**State Significant Development Application for Crown Sydney Hotel Resort
(SSD 6957), 51a Hickson Road, Barangaroo - Notice of Exhibition**

Attachment 1 – Issues identified in relation to Traffic, Transport and Parking

Figure 14 Future City Centre Bus Network

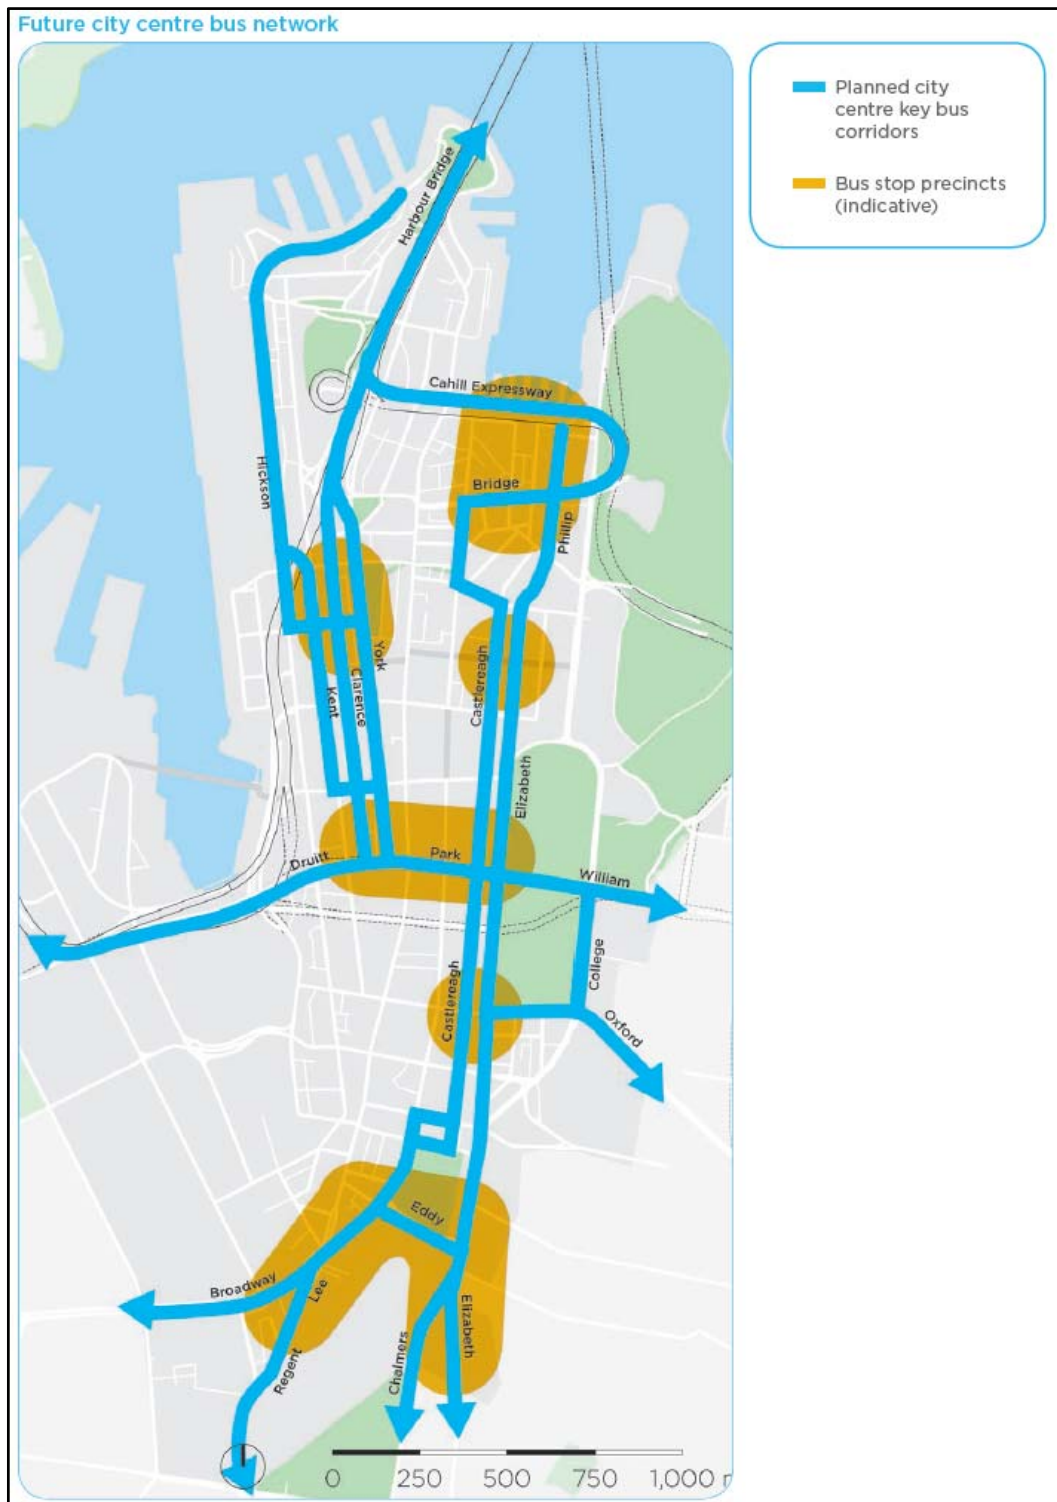
- Section 2.3.2 (Page 45) – Construction is scheduled to commence in late 2015 and will take four years to complete (not in late 2014 and will take five to six years to complete).
- Sections 2.4.3 and 2.4.4 (Page 16) – Latest information in relation to the Sydney Metro needs to be included in Section 5 as per public announcements.
- Section 2.4.3 (Page 16) – The South West Rail Link is complete and now open.
- Section 2.5 (Page 15) – Latest information in relation to Barangaroo Ferry Hub needs to be included in Section 5 as per public announcements.
- Section 2.6 (Page 18) – some of the statements are incorrect. The recently released New CBD Bus Network brochure should be reviewed and the text in Section 5.3 amended accordingly.
- Section 2.6 (Page 19) – Figure 14 does not reflect the recent release of information on the new CBD bus network.

Figure 33 Future City Centre Bus Network
Source: Sydney City Centre Access Strategy (NSW Government, 2013)

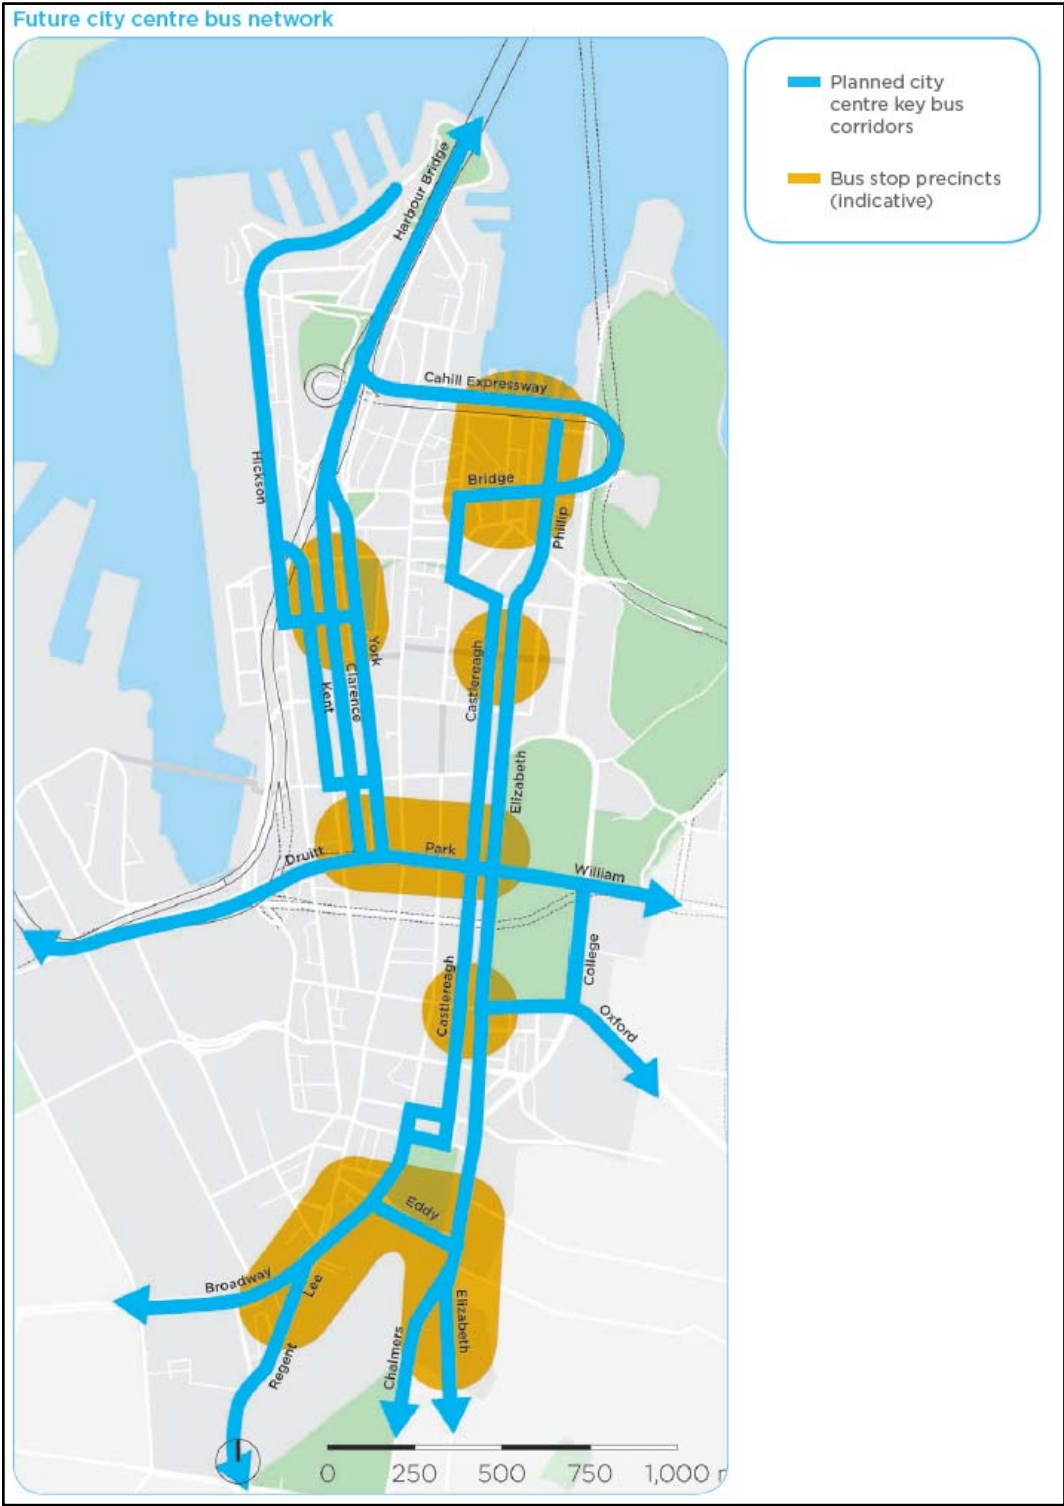
- Section 5.3 (Page 50) - Figure 33 does not reflect the recent release of information on the new CBD bus network.
